**New Wee Waa High School (SSD-21854025)
EIS**

Attachment A

Detailed advice to DPIE Planning & Assessment regarding the New Wee Waa High School (SSD-21854025) EIS

STORMWATER CHANNEL 1 - LONGITUDINAL SECTION CH000 - CH350

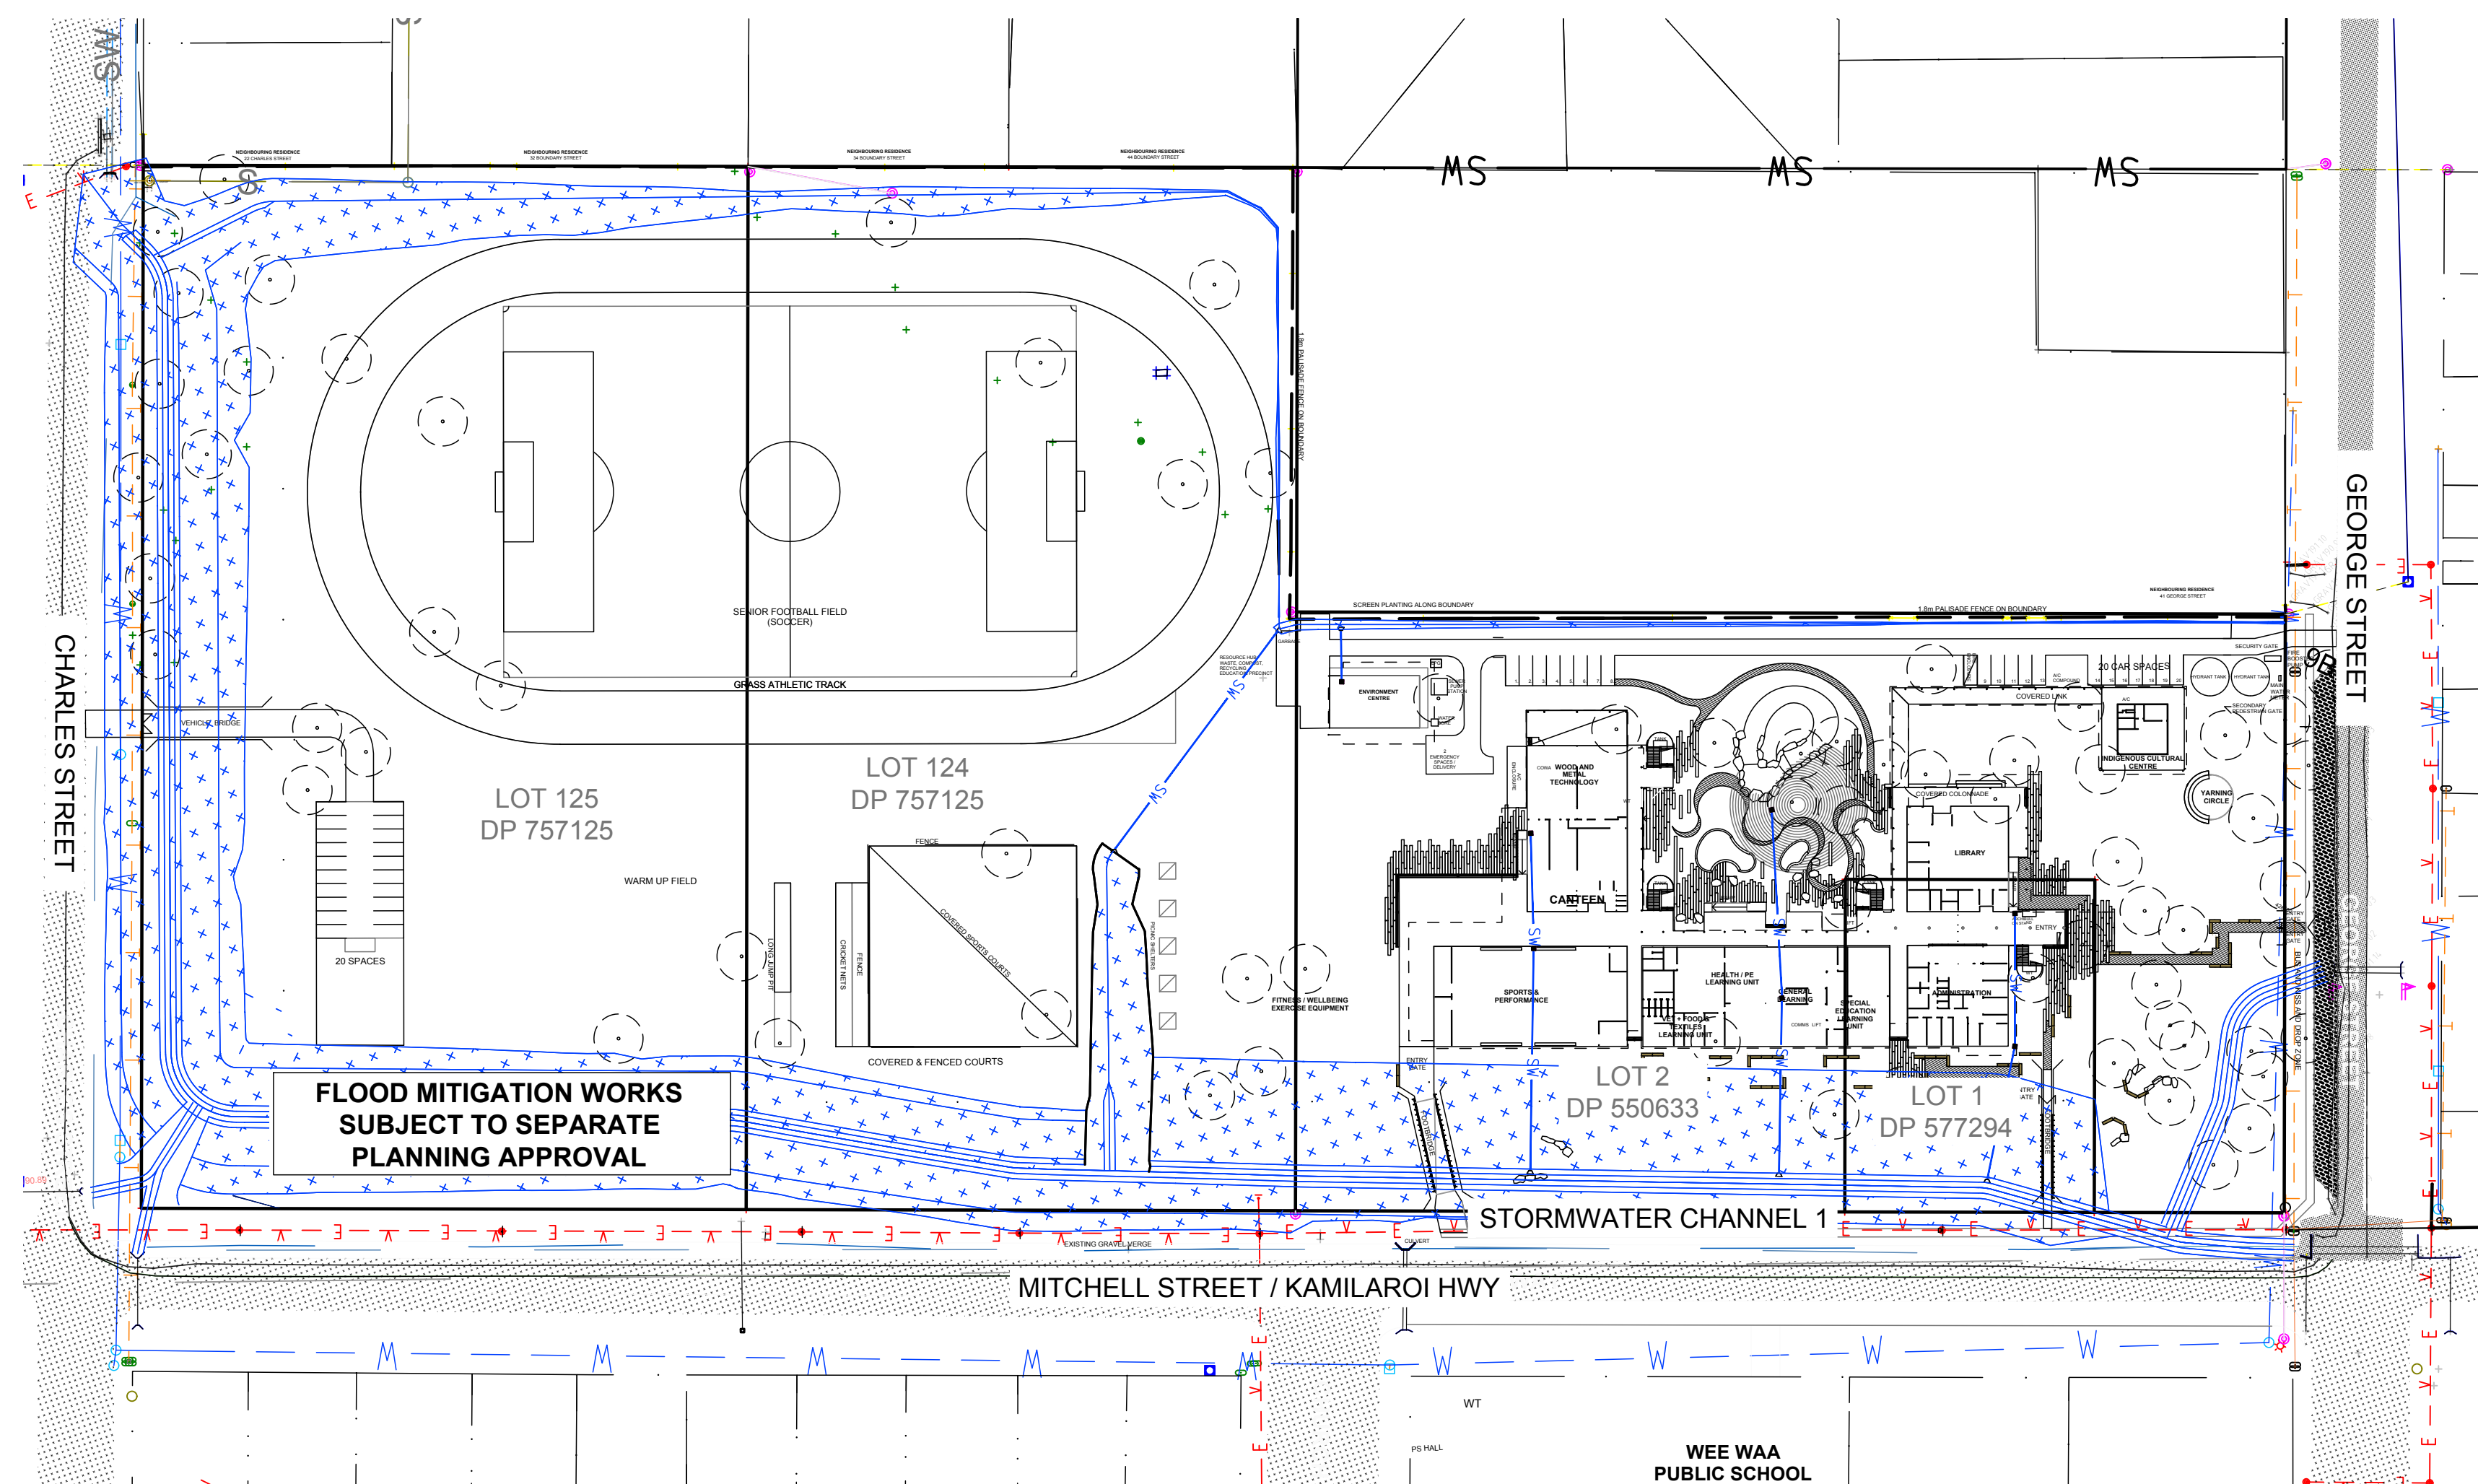
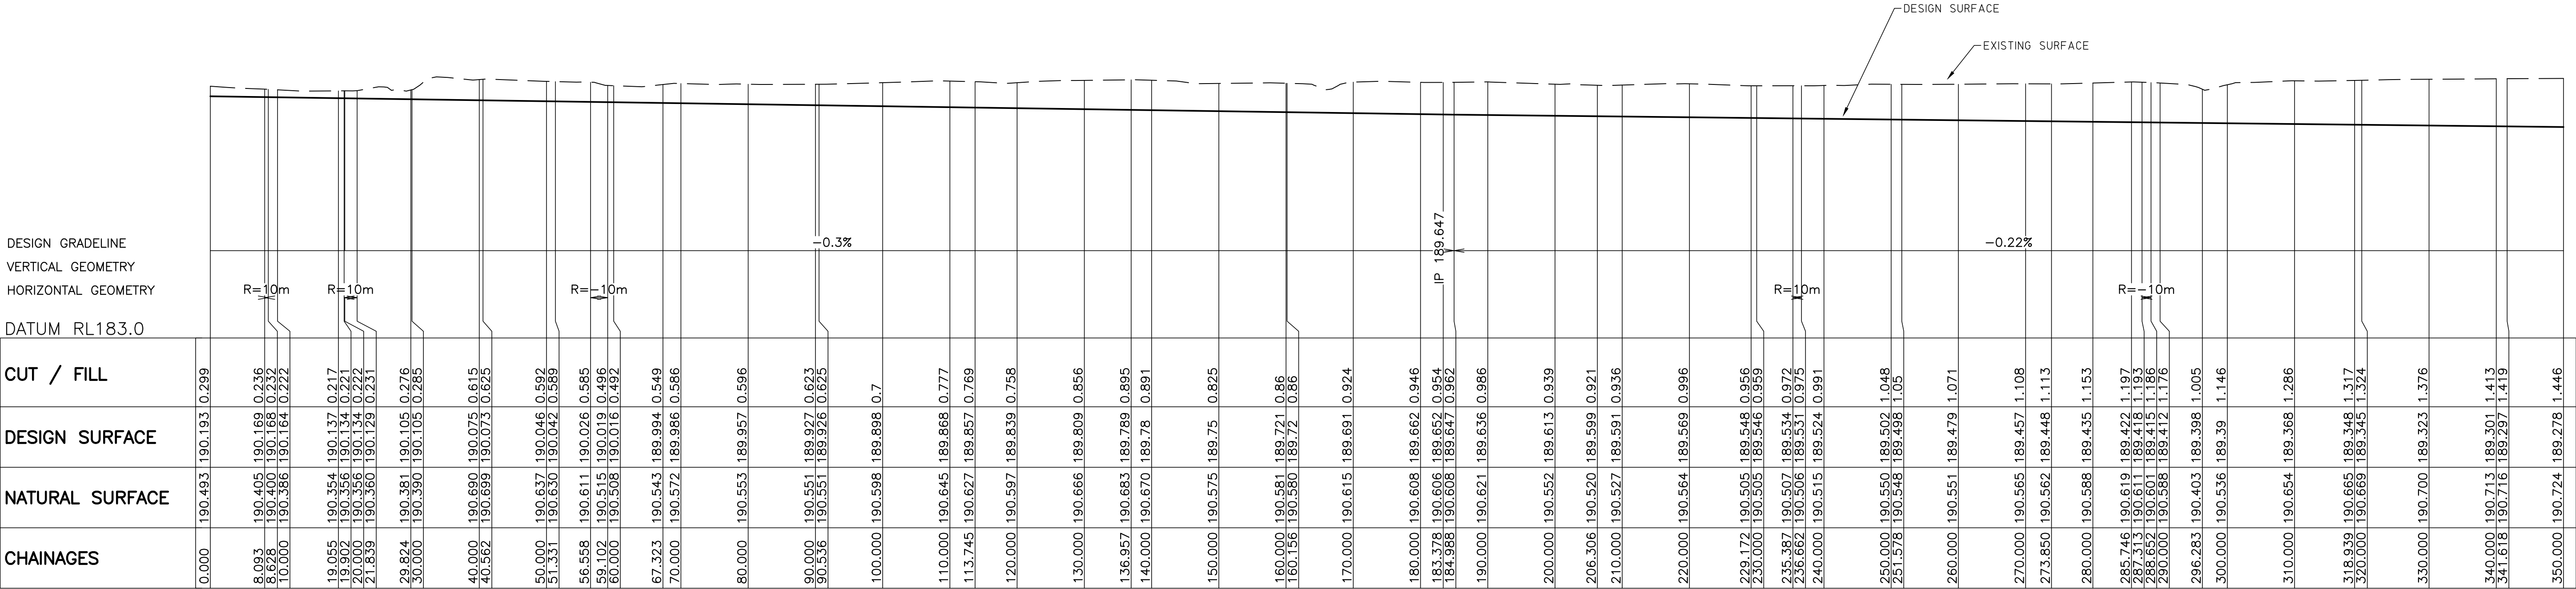
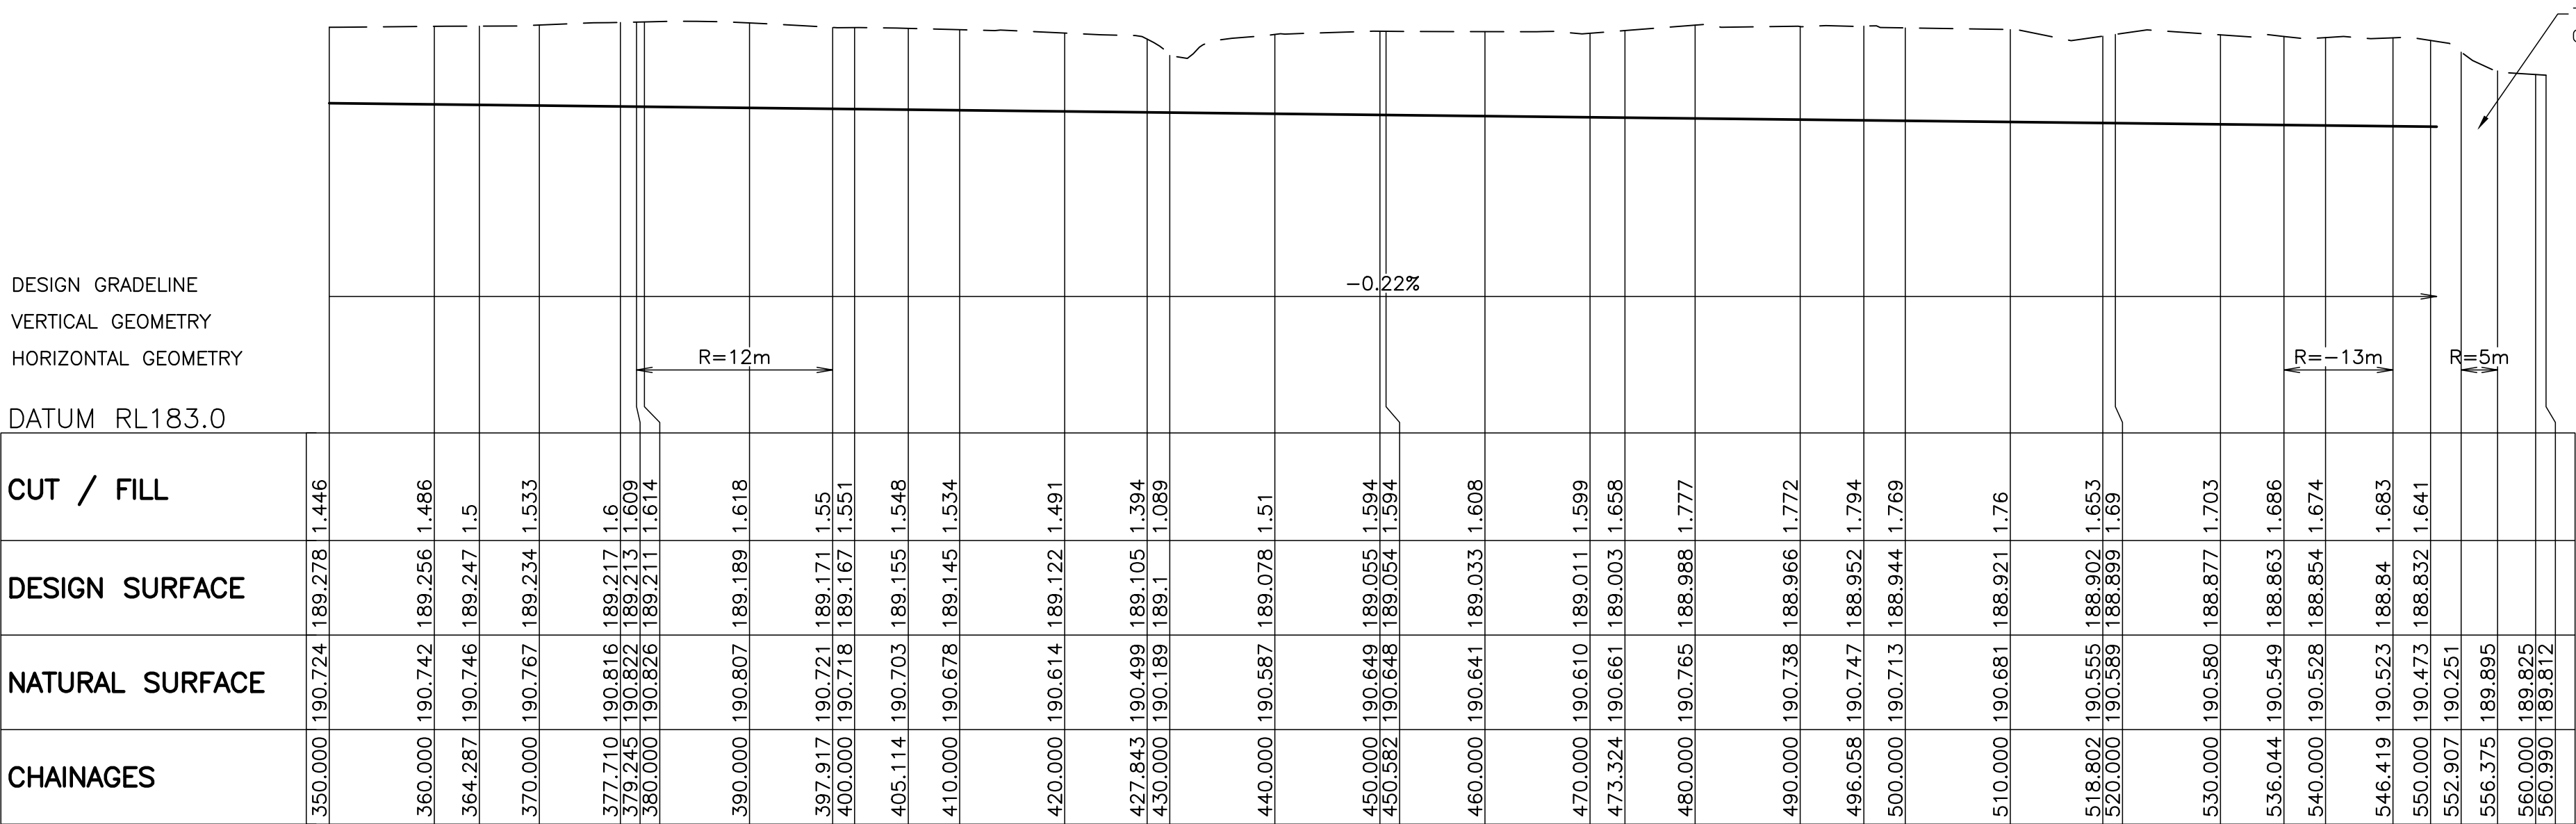
Significant stormwater works are proposed on the site to manage local runoff. There are no natural or mapped waterways within or nearby to the site so the risk to waterfront land is limited to downstream impacts. Conveyance of runoff within and downstream of the site needs to ensure channel stability and to mitigate downstream impacts such as erosion and sedimentation.

Should the proposal be approved, the proponent should prepare a Soil and Water Management Plan to address stormwater management and sediment and erosion control during construction and operation. The plan is to address the requirements of the guideline *Managing Urban Stormwater: Soils and Construction* (Landcom 2004) and to ensure peak discharge from the project site is not increased.
